Ribble Valley Borough Council
Housing & Development Control

Application no: **3/2021/0841**

Address: **Unit2 and Unit 2a (Pendle Mill) Mill Lane Gisburn BB7 4LN**

Proposal: **Proposed change of use from B8 (Storage/Distribution) to B2 (General Industry).**

CHANGE OF USE B8-B2
PENDLE MILL, OFF MILL LANE, GIBBURN BB7 4LN
SITE PLAN AS PROPOSED

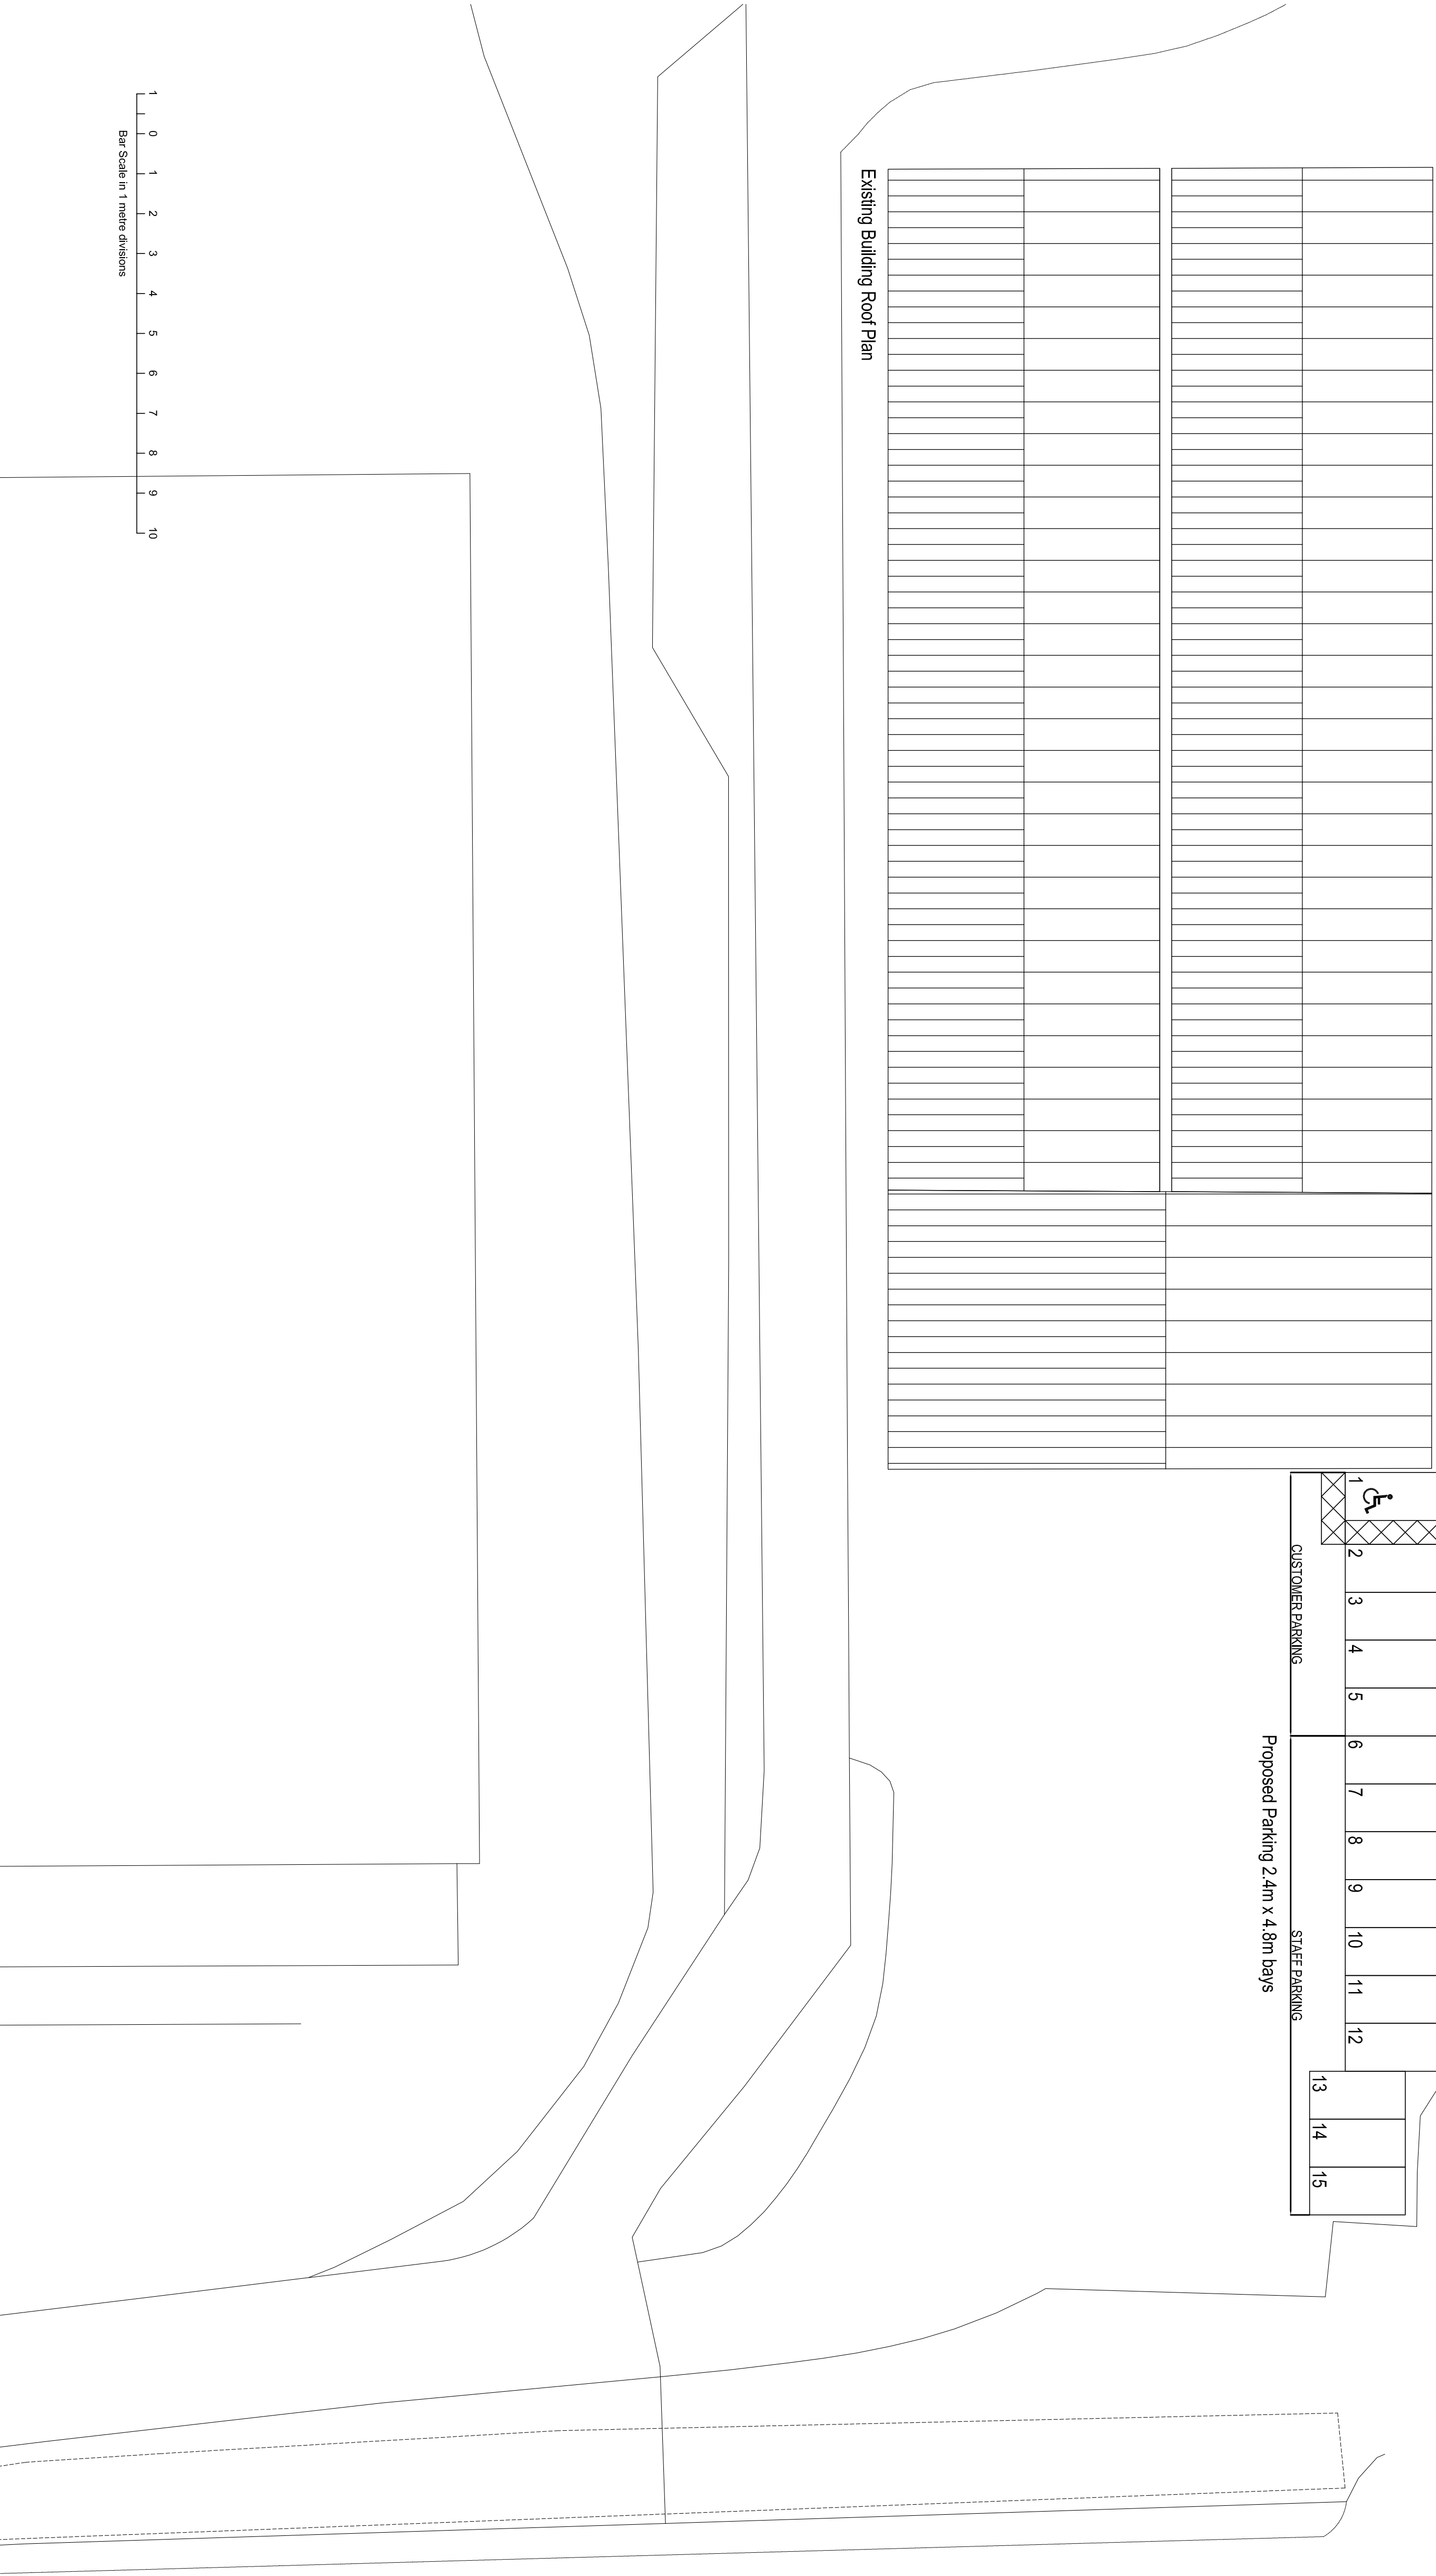
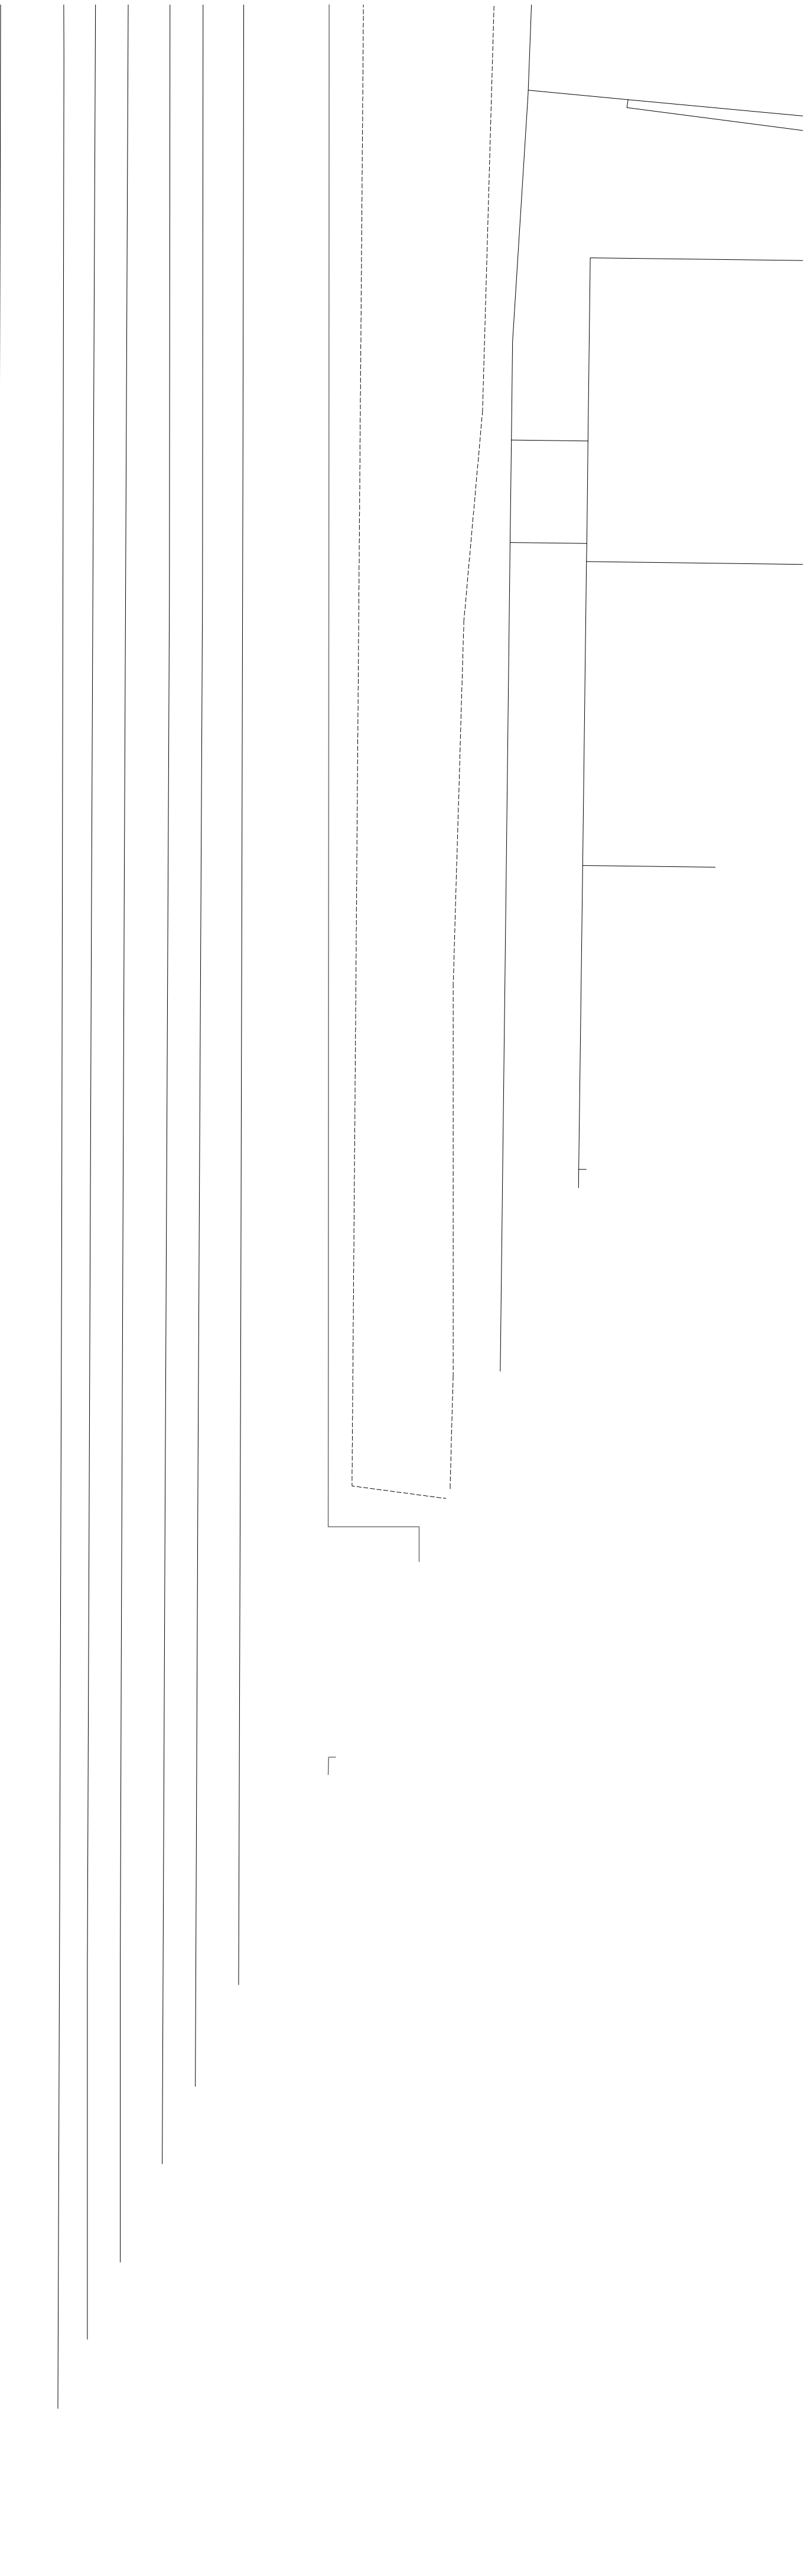
The LHA have reviewed the Application Form as provided by the Applicant and shown on the Local Planning Authorities website and require further clarification regarding the size of the existing building. This is because the LHA are unsure whether the internal floor area of the building is 2117m² or 4234m². Either way, the site will have a considerable shortfall in parking with the site only providing 15 car parking spaces as shown on IP drawing number 6 titled "Site Plan as Proposed."

The LHA advise the Applicant for the site to comply with the Joint Lancashire Structure Plan, a B2 development with an internal floor area of 2117m² is required to provide 47 car parking spaces, while a B2 development with a floor area of 4234m² is required to provide 94 spaces. Therefore, there is a shortfall of 32 and 79 car parking spaces, respectively.

The LHA by reviewing the site are aware that the site will be unlikely to provide the full minimum parking standards as defined in the Joint Lancashire Structure Plan, due to the existing parking area being small but a few more spaces can be provided. However, for the LHA to accept any shortfall in parking, the LHA require further information from the Applicant.

Ideally, as a minimum, the LHA require the same number of parking spaces at the site as the premises in Nelson but should this not be possible the further information in the guise of the Operation Statement, will allow the LHA to fully assess the parking supply and demand at the site.
